WEST SUSSEX COUNTY COUNCIL CONSULTATION

TO:	Arun District Council FAO: Mr A Wood
FROM:	WSCC - Highways Authority
DATE:	14 May 2019
LOCATION:	Chandlers Garage Bmw House Water Lane Littlehampton BN16 4EH
SUBJECT:	A/45/19/PL Demolition of existing buildings (car show room, workshops and Phares Courtledge) and erection of 19 dwellings, a convenience store, a community building, public toilets and associated car parking and landscaping - This application affects the character and appearance of the Angmering Conservation Area.
DATE OF SITE VISIT:	
RECOMMENDATION:	More Information

The Local Highways Authority has assessed the Transport Statement and associated plans submitted by the applicant and requests clarification on the following points.

Typical Access Gate - 1800mm high

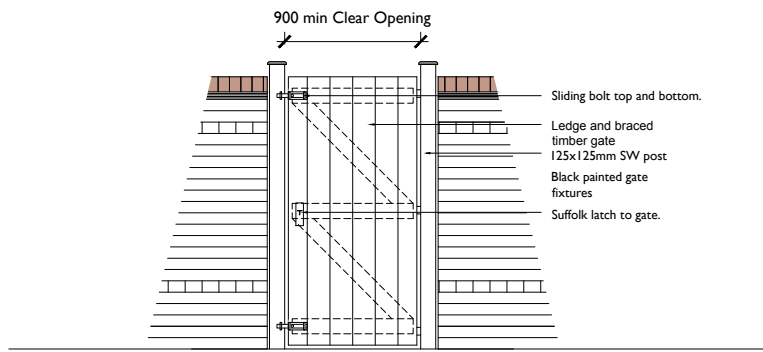
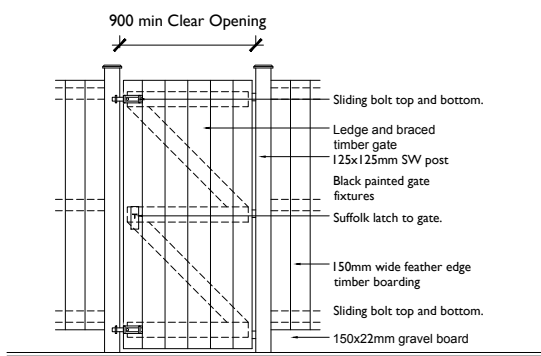
The pedestrian access adjoining Cumberland Road should open into the site, the gated access should not swing into the Publicly Maintained Highway.

Fig 4. Site Layout

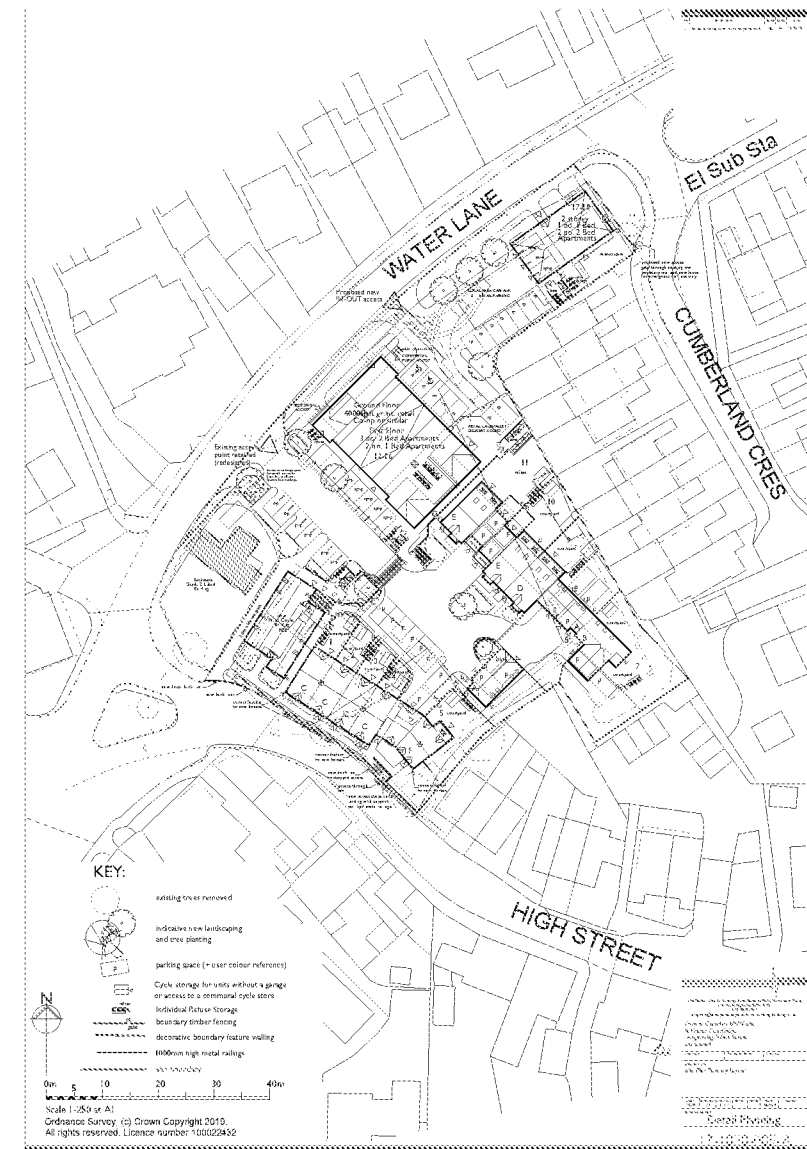
Footways are to be created to standards as outlined within the Department for Transport's Inclusive Mobility at a minimum 1.5m wide.
The disabled parking bays do not appear to standard. Where disabled bays are perpendicular to the access aisle, an additional width of at least 1200mm along each side

should be provided. Where bays are adjacent the same 1200mm space can serve both sides. There should also be a 1200mm wide safety zone at the vehicle access end of each bay to provide boot access or for use of a rear hoist and a raised sign at the head of the reserved bay.
